Harnett County Government Complex  
307 W. Cornelius Harnett Boulevard  
Lillington, NC 27546

**Re: Status of Improvement Permit Application # 14-5-33700**

An attempt was made to evaluate your property for the purpose of issuing an Improvement Permit. The evaluation could not be completed for one or more of the following reasons.

SITE PLAN APPROVAL SEP
 DISTRICT RA 30 USE
 #BEDROOMS 4
 Date 5-21-14
 Zoning Administrator *McArthur*

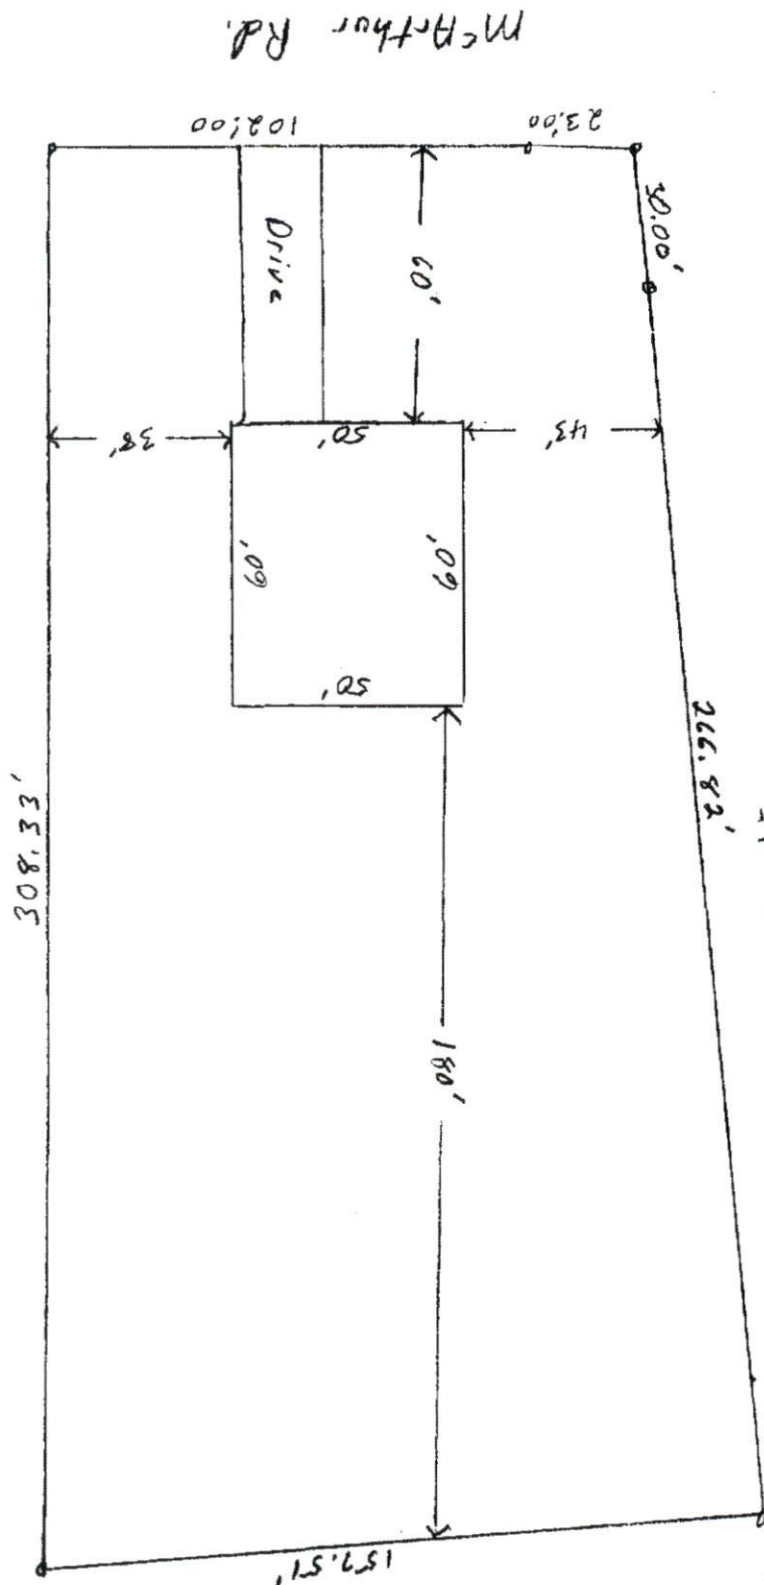
- 1. Use pink flags to mark property lines and irons that are set by surveyor need to be visible (\$25.00 fee incurred)
- 2. Use orange flags to mark house corners (\$25.00 fee incurred)
- 3. Directions not clear to property (\$25.00 fee incurred)
- 4. Property needs only brush or vegetation removed
- 5. Driveway not shown on site plan
- 6. Backhoe pits required
- 7. Other *House size should match site plan*
